Re: Portland Retirement Residence

These are responses to your email comments/redlines dated March 23, 2016.

A7.1b

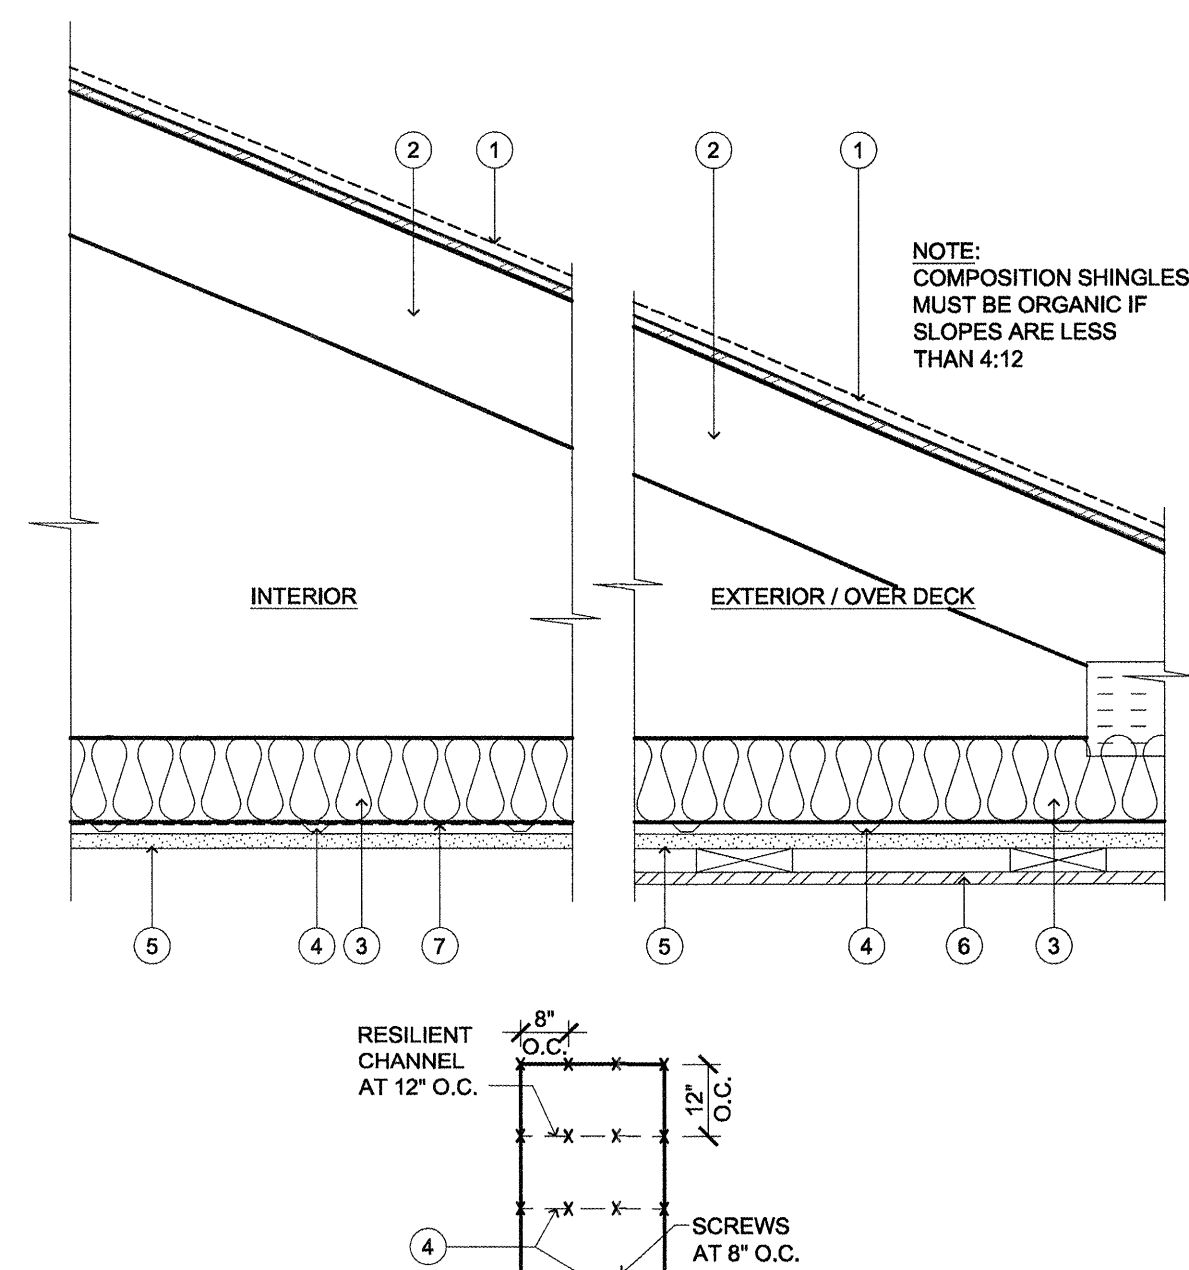
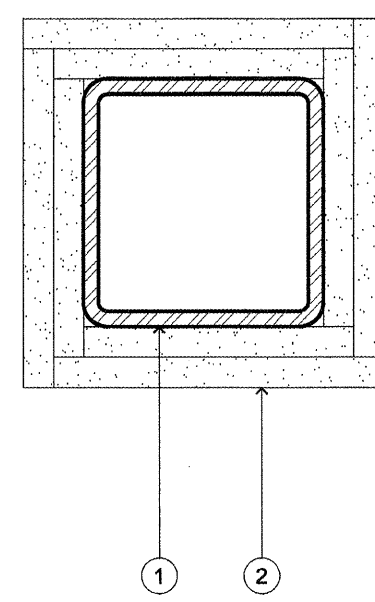
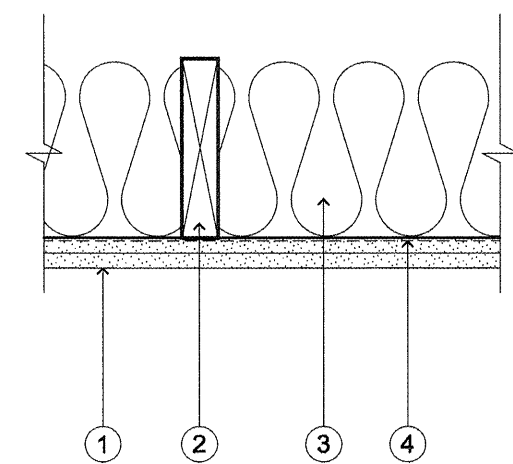
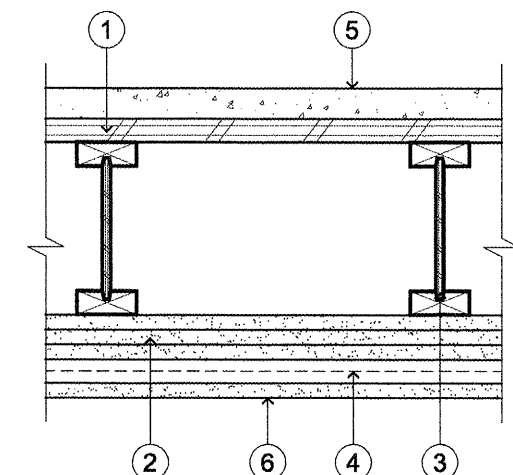
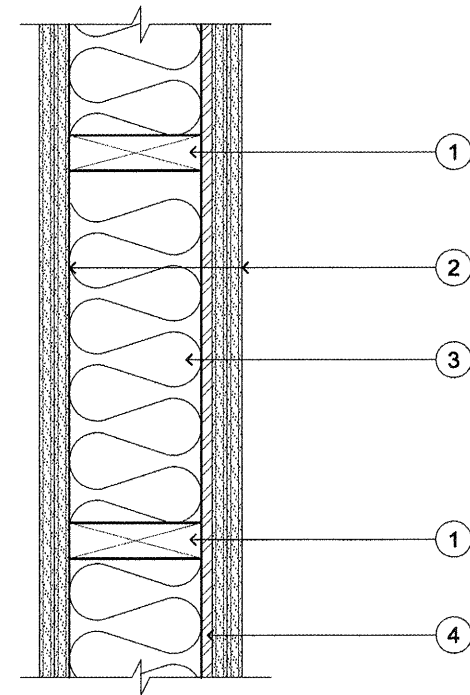
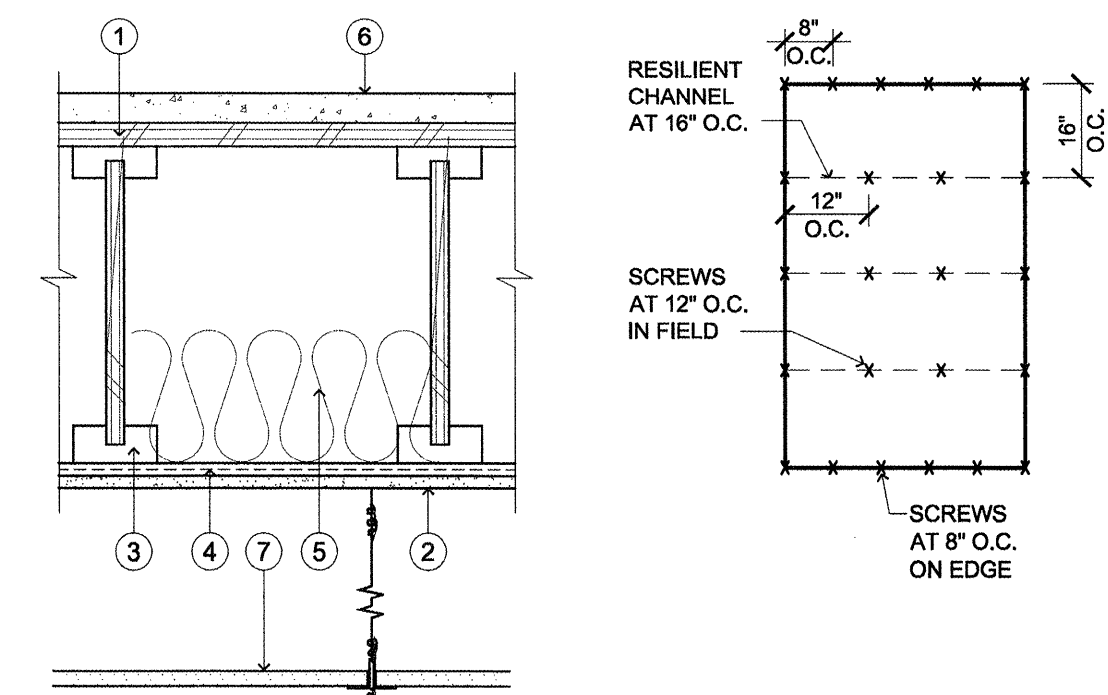
14. Label all floor and wall assemblies. The floor assembly N for the roof deck or J for elevator shaft is not called off. Please revise.

Please note that A7.1b has had the missing assemblies added.

SHEET
A0.1

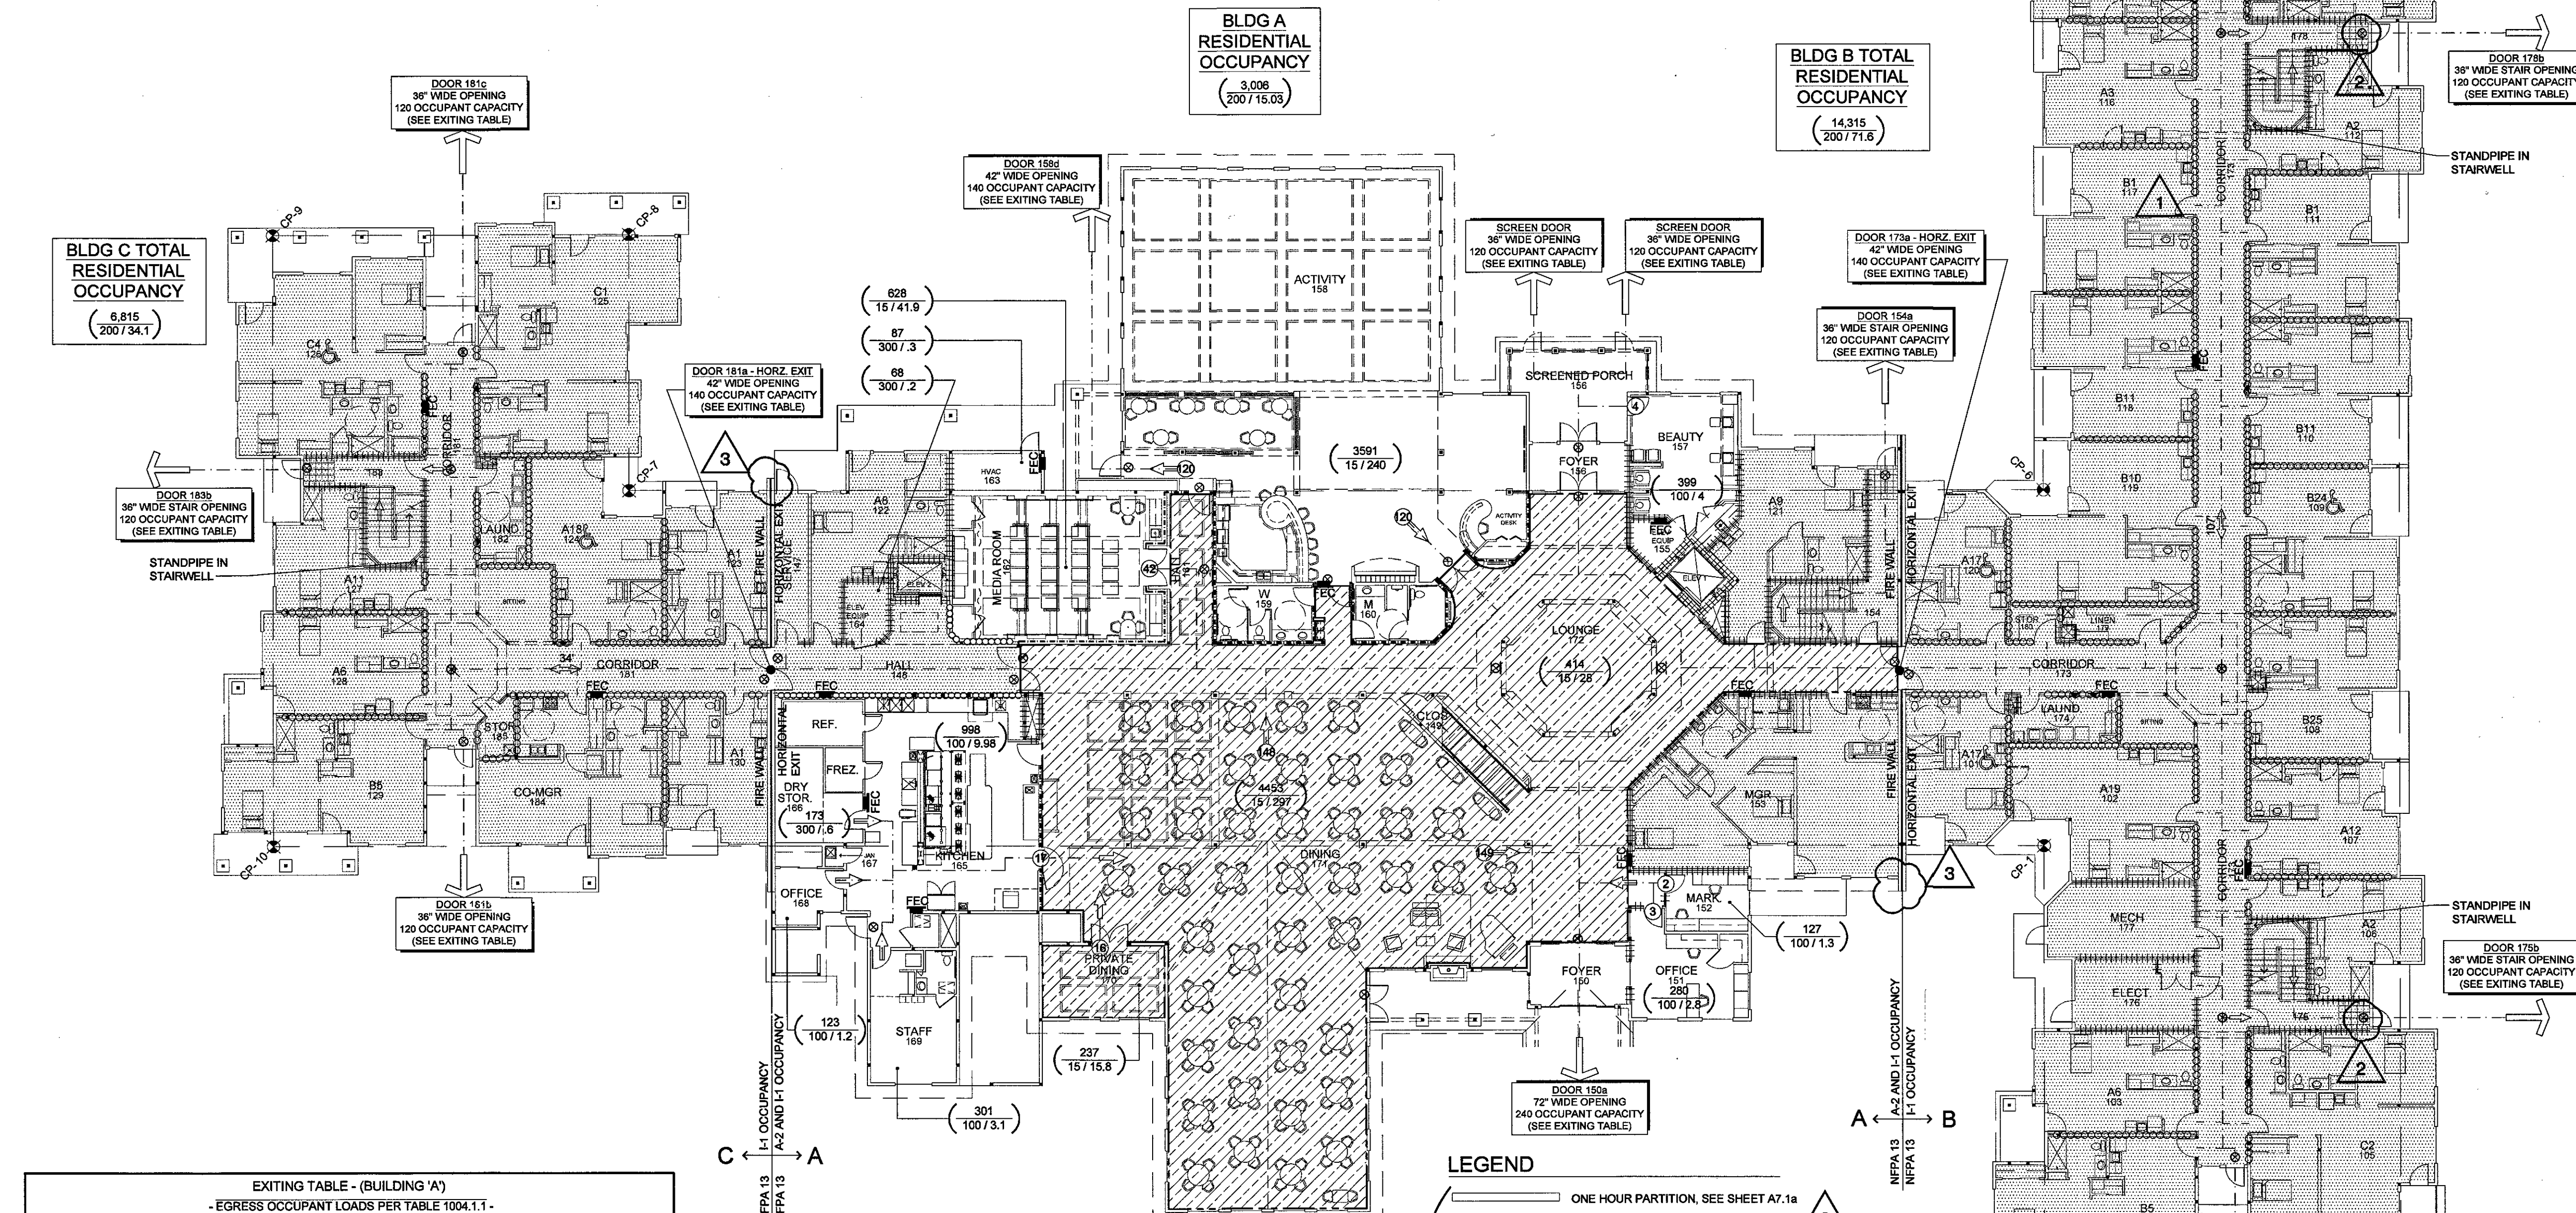
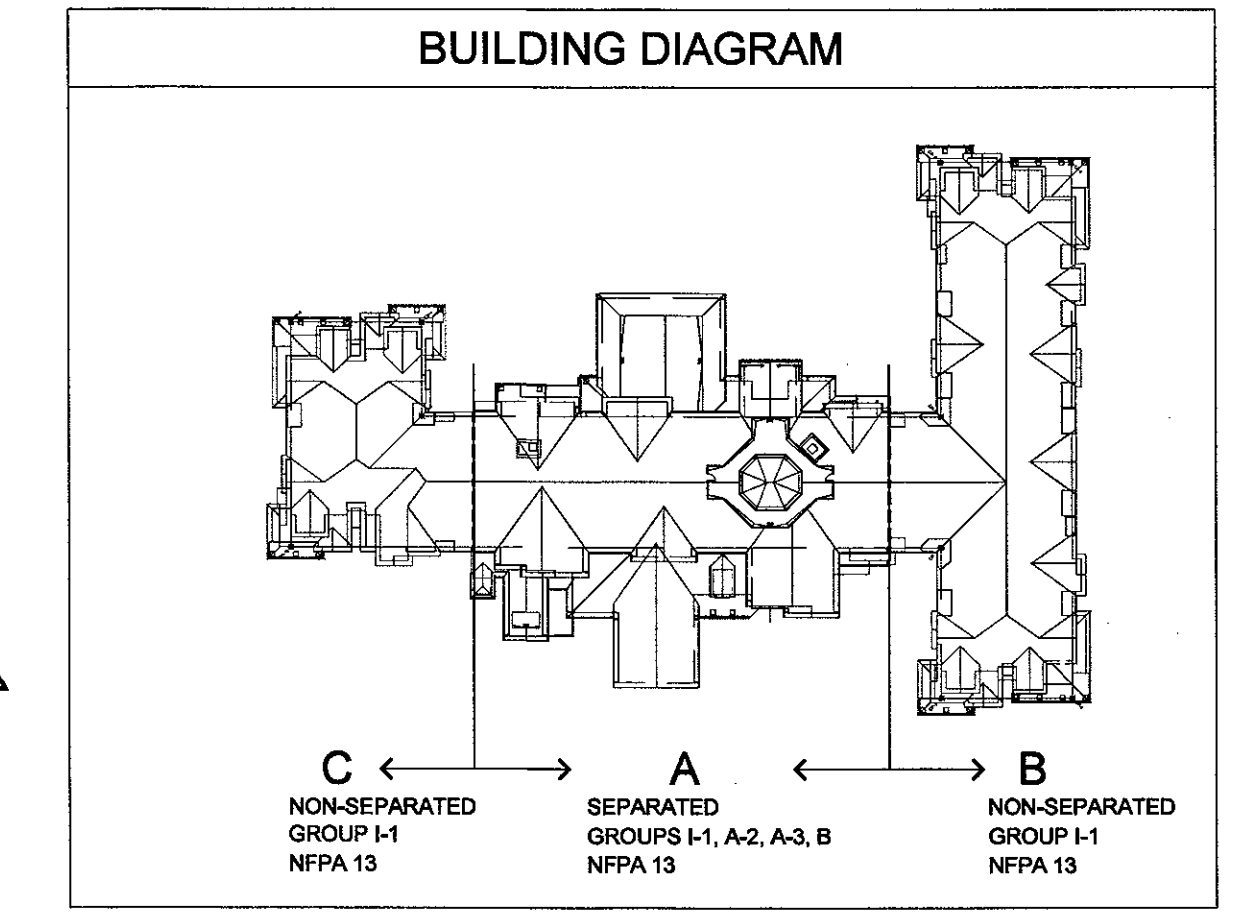
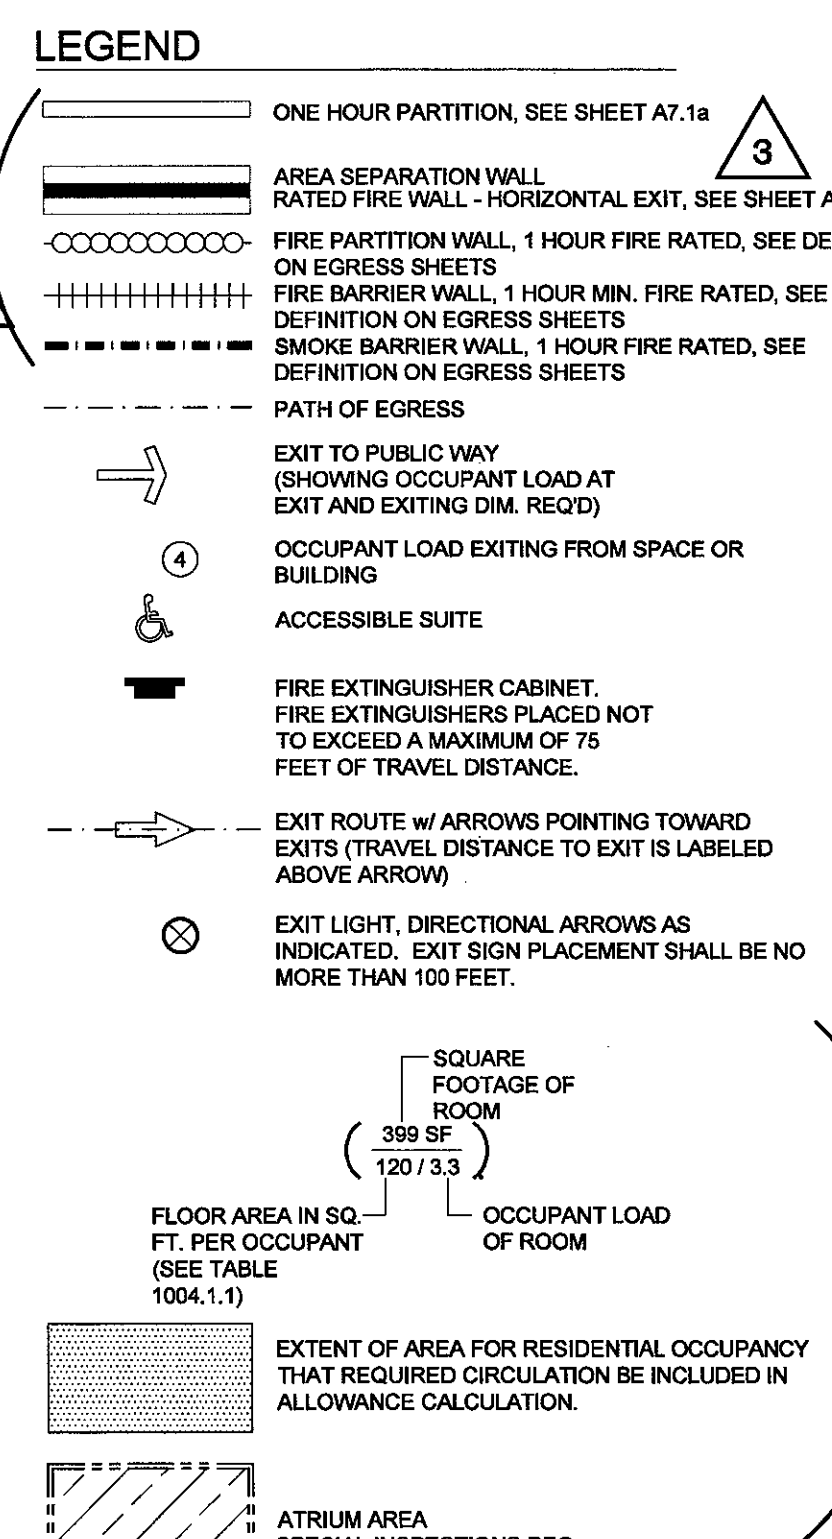
1. Clarify why one of the two fire walls shows an extension beyond the exterior wall and the other does not? Provide continuity on all plan sheets. Reference the code section this is associated with in the code analysis.

Please note that we have revised the firewalls extensions on A0.1 to be consistent to 706.5.2
